**Fenwick Solar Farm
EN010143**

**Applicant's Response to Examining Authority's First Written
Questions (ExQ1)**

Document Reference: EN010152/APP/8.21

May 2025
Revision Number: 00

Sheet Number
 60698207-ACM-HGN-00-DR-CE-2002

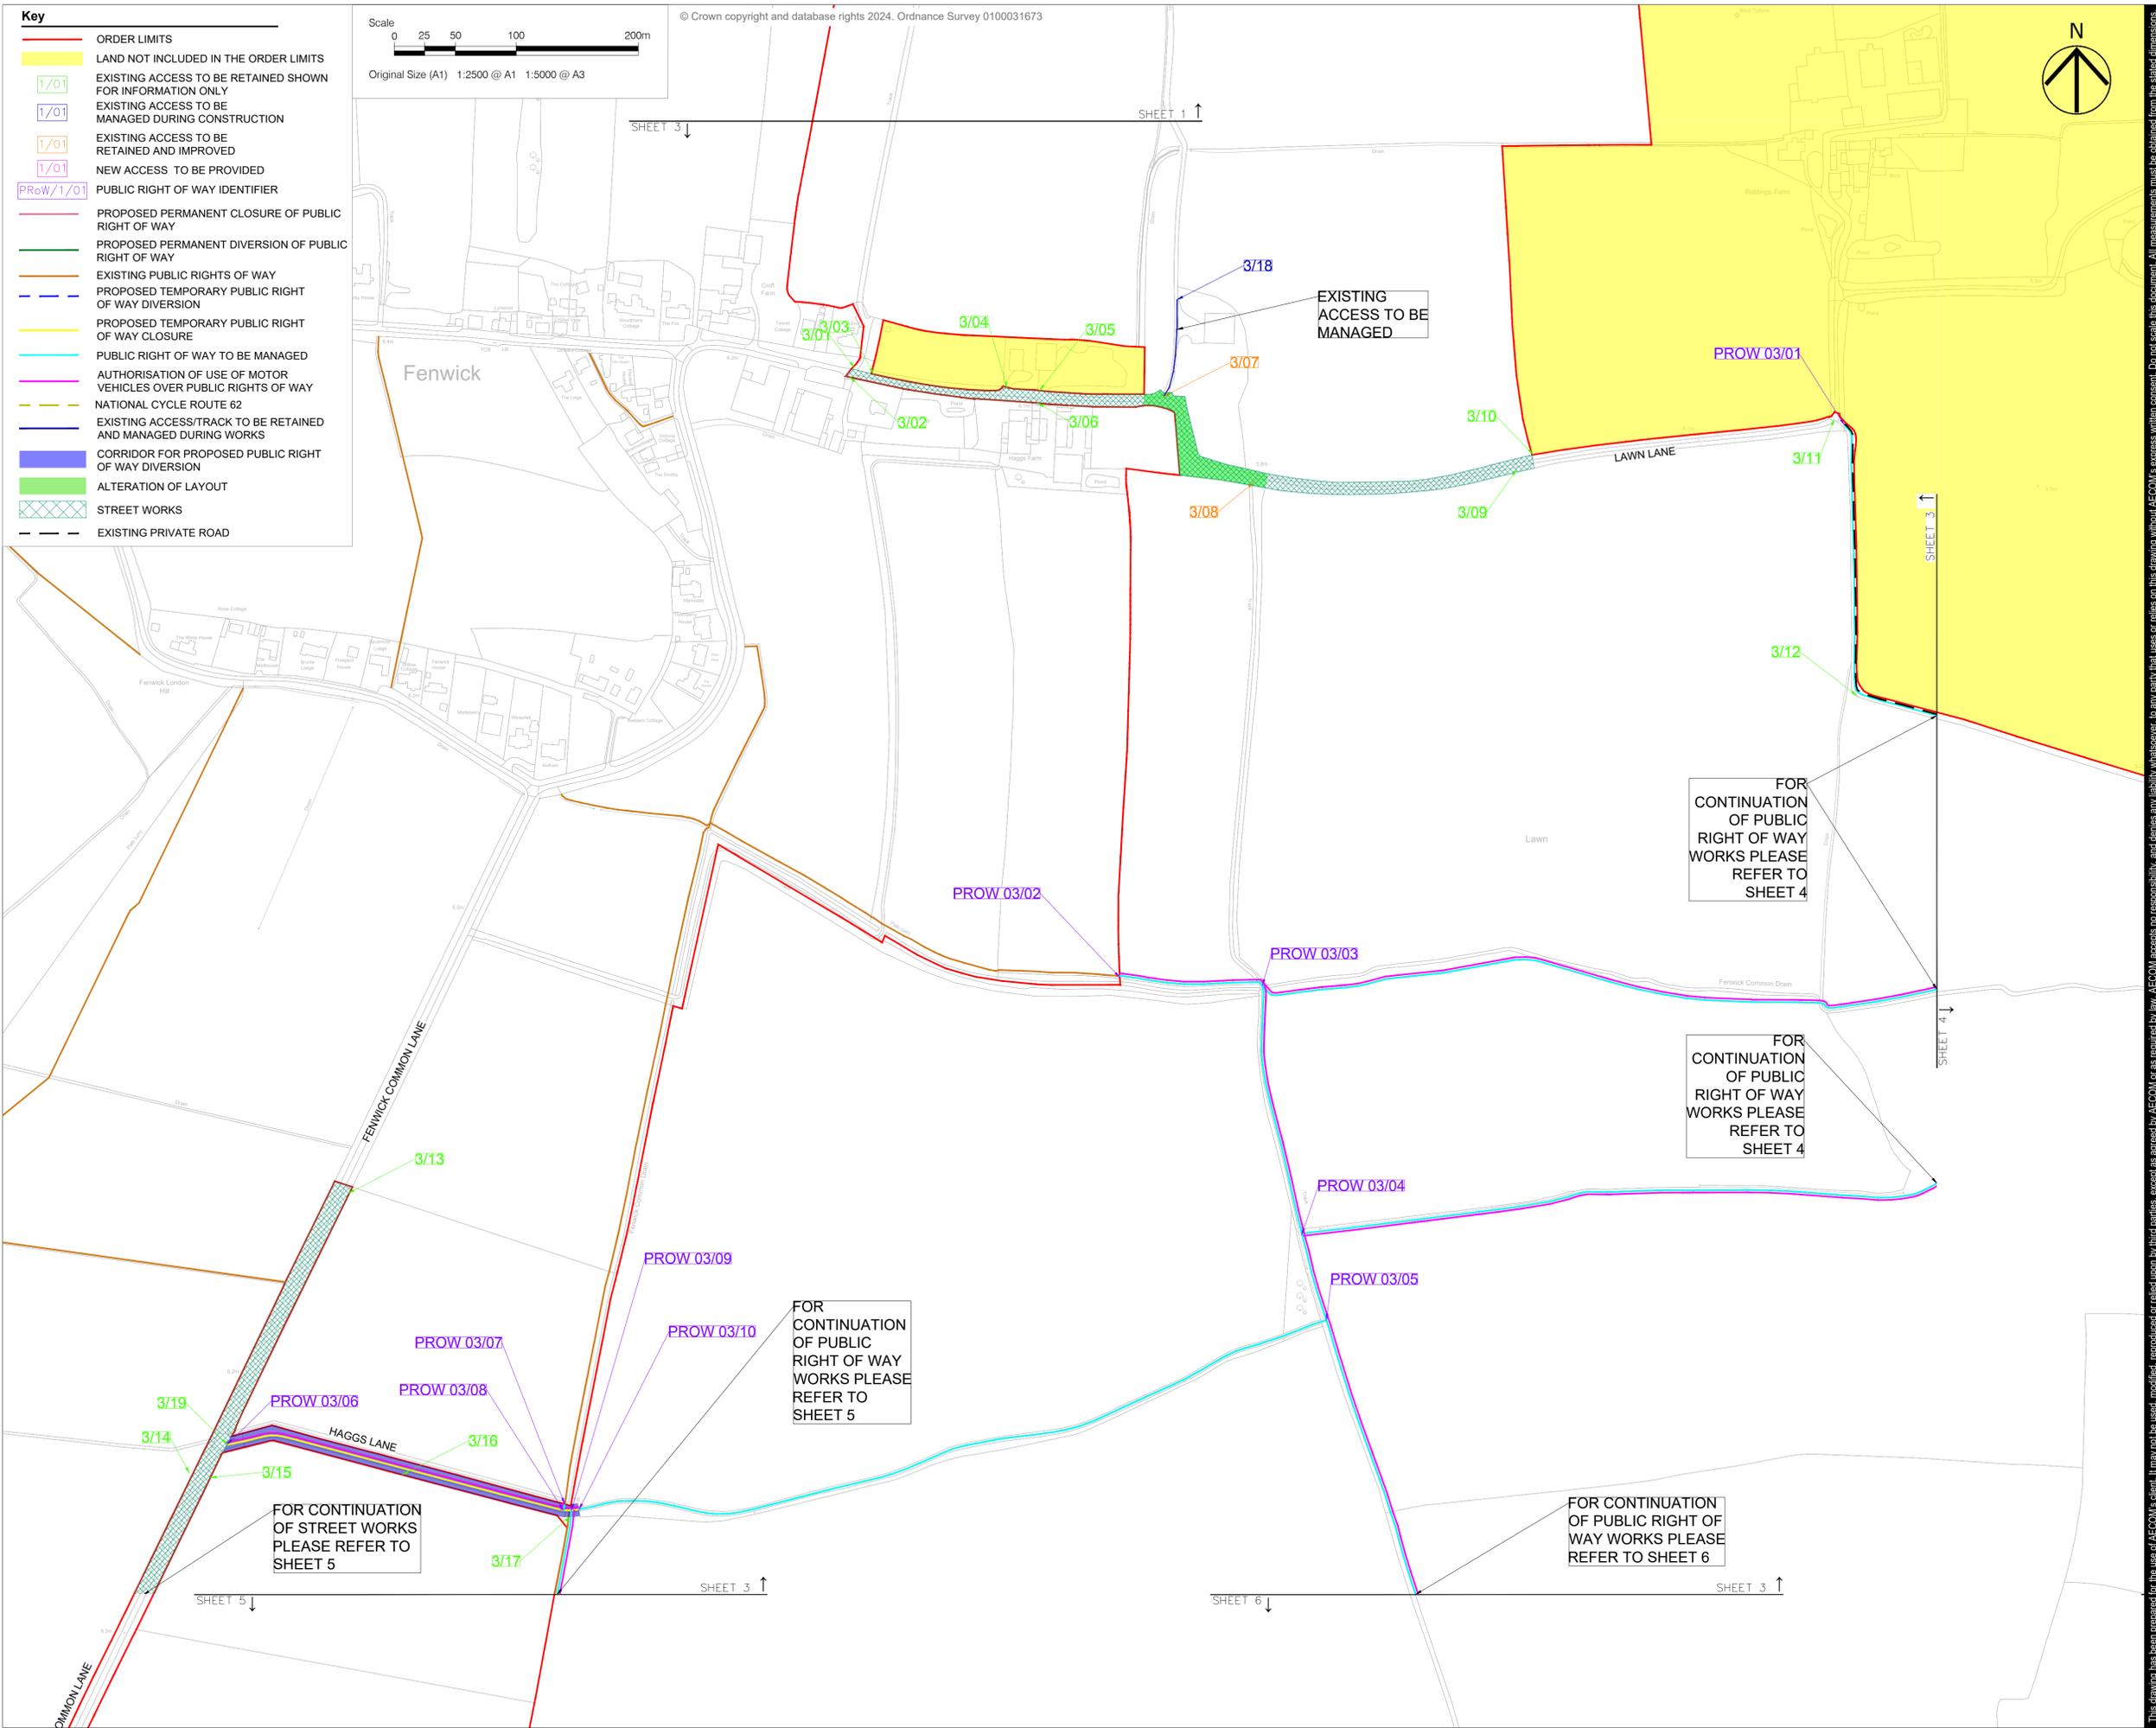
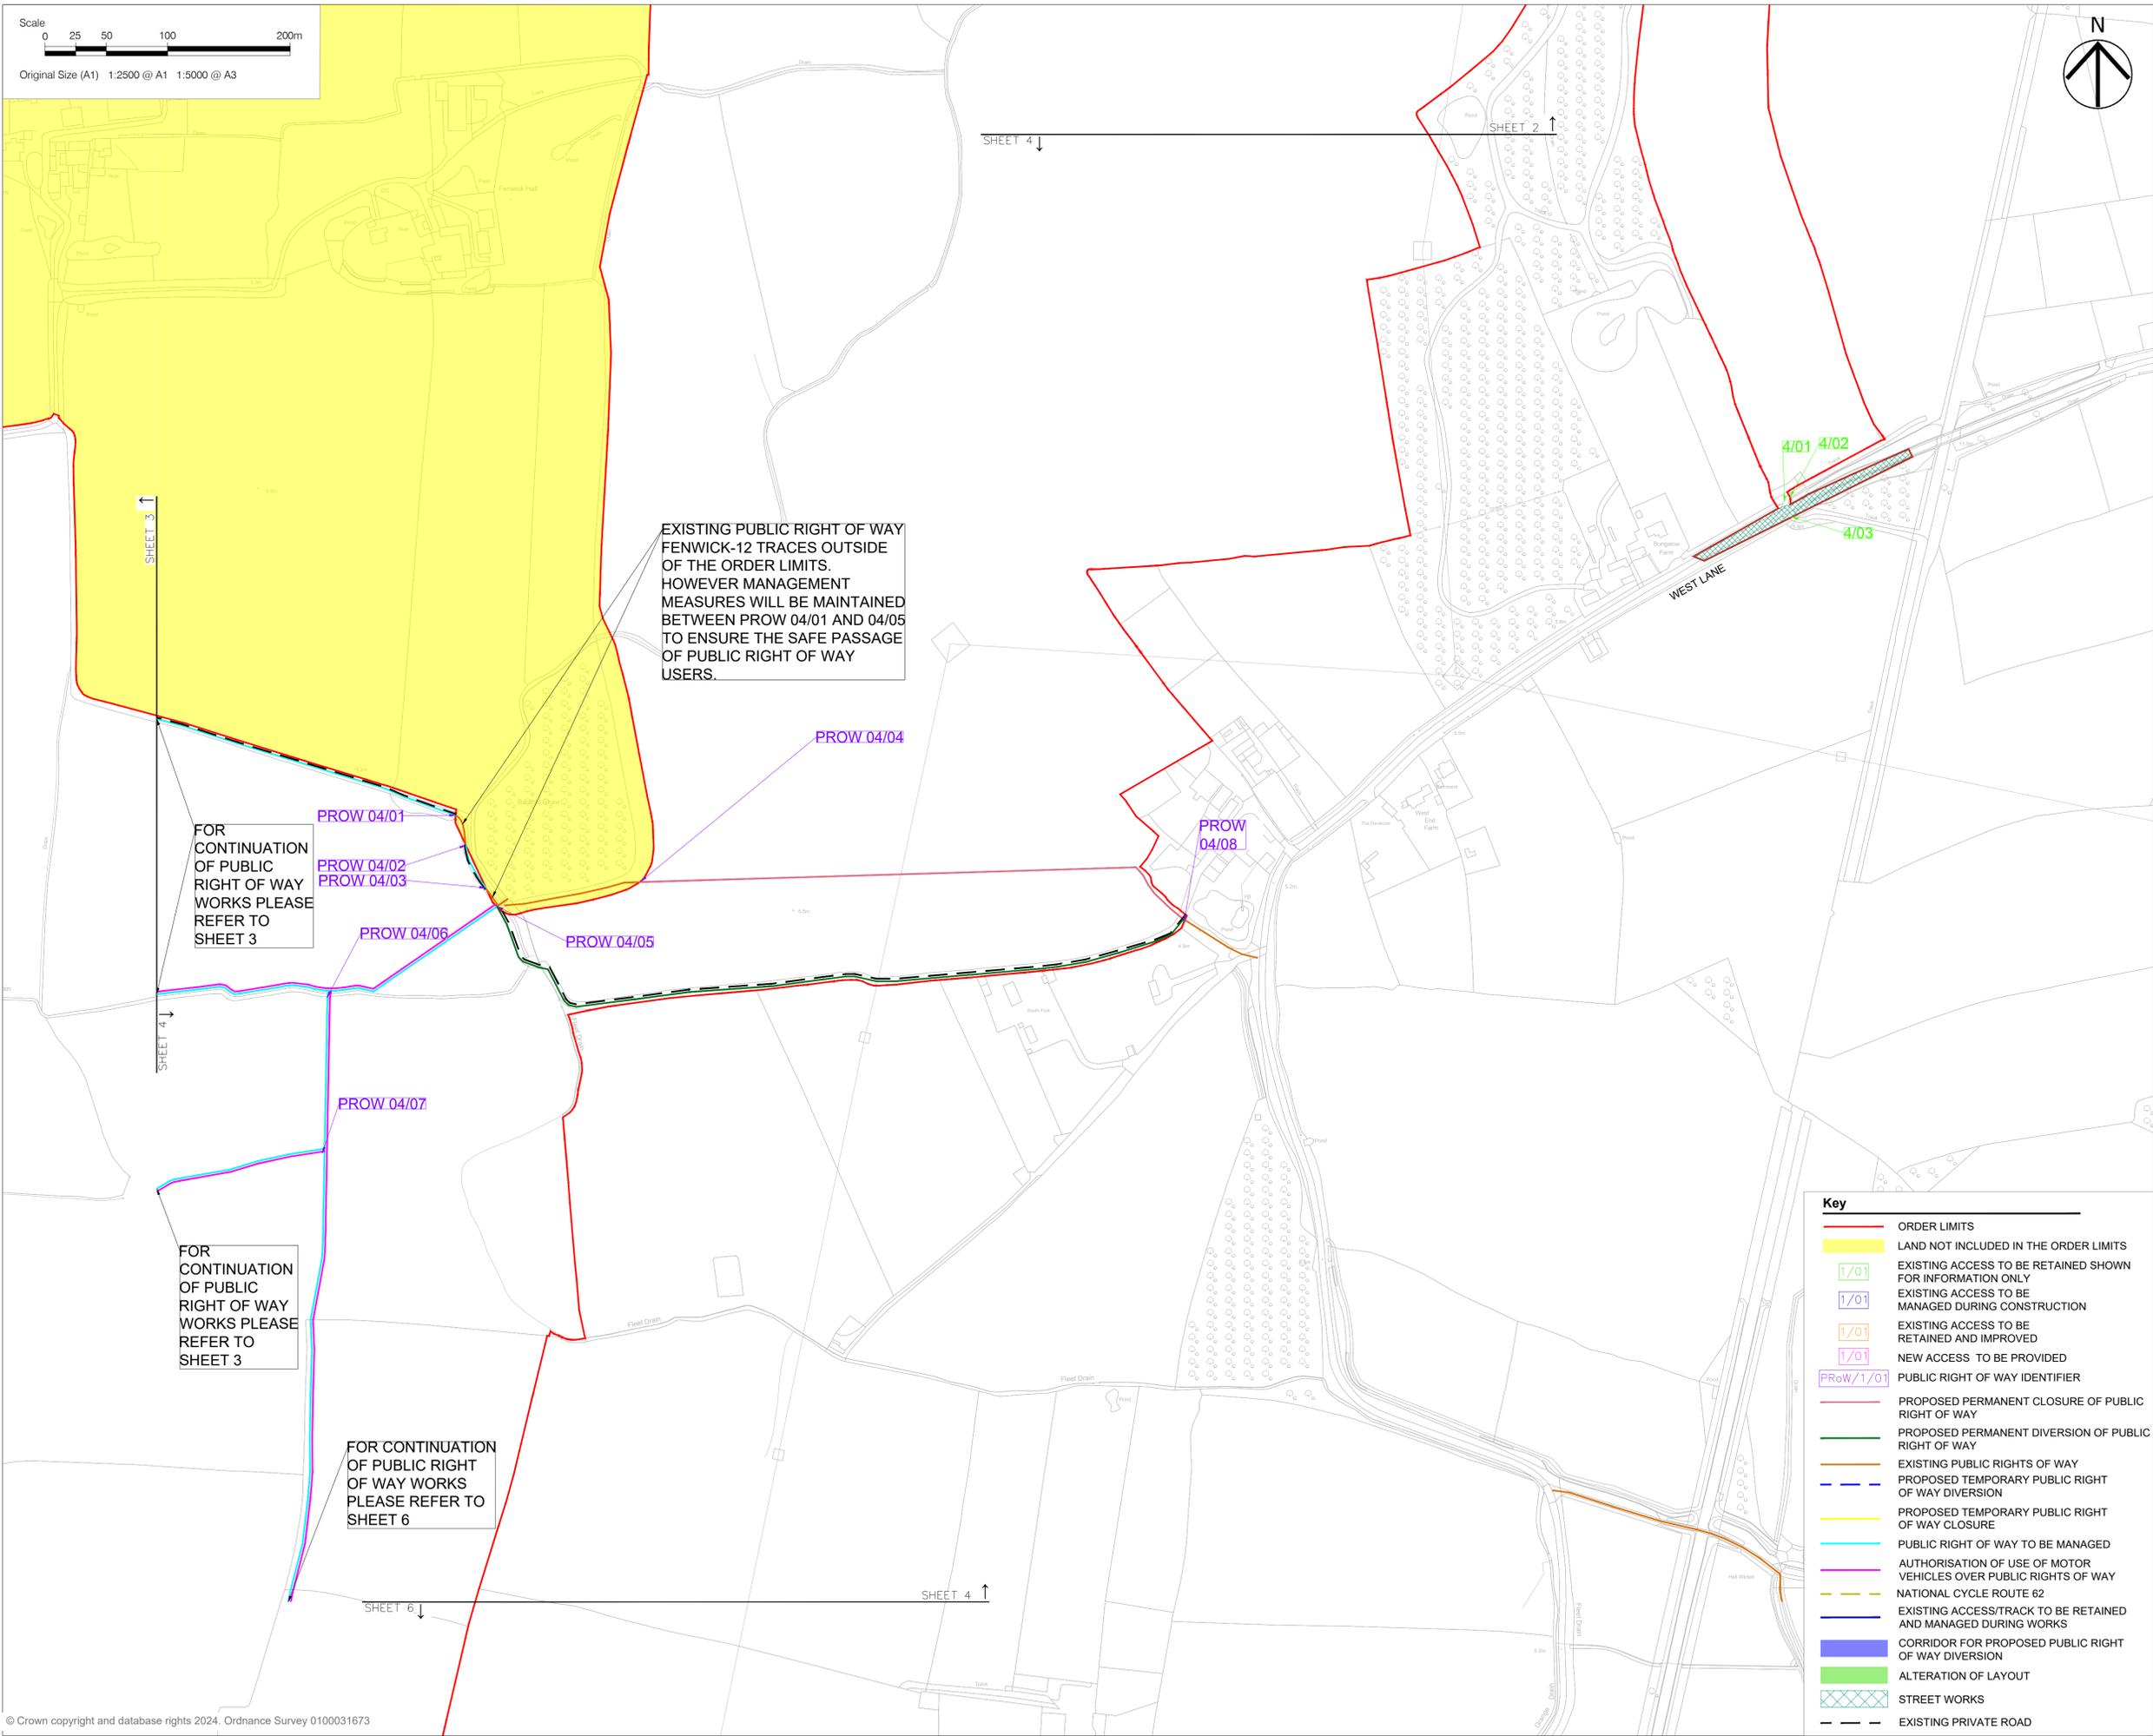
1.1.19	Applicant	<p>Schedule 4 (Streets subject to street works)</p> <p>The ExA notes the use of the words 'within proximity of' in this schedule are insufficiently precise. Please amend to a more precise form of words (eg. 'between points [x] and [y]') or provide a further justification for their use.</p>	<p>The Applicant considers the wording is sufficiently precise when reviewing the wording as against the Streets, Rights of Way and Access Plan (Revision 03) [EN010152/APP/2.3], as while the access points are used as a locational tool to help identify the area of streetworks within each sheet, the powers themselves are constrained instead to “the length shown in green patterned hatching”. The Applicant considers that to further define these</p>

ExQ1	Respondent	Question	Applicant's Response
			<p>extents using additional markers confirming the various edges of these streetworks would make this Plan overly cluttered and less applicable for the undertaker and local streets authorities.</p> <p>It is further noted that this approach to identifying streetworks (ie to rely on the areas as shaded in highlight or hatching) has been adopted and considered sufficiently precise on other recently made solar DCOs, including the Gate Burton Energy Park Order 2024, the Mallard Pass Solar Farm Order 2024 and the East Yorkshire Solar Farm Order 2025.</p>
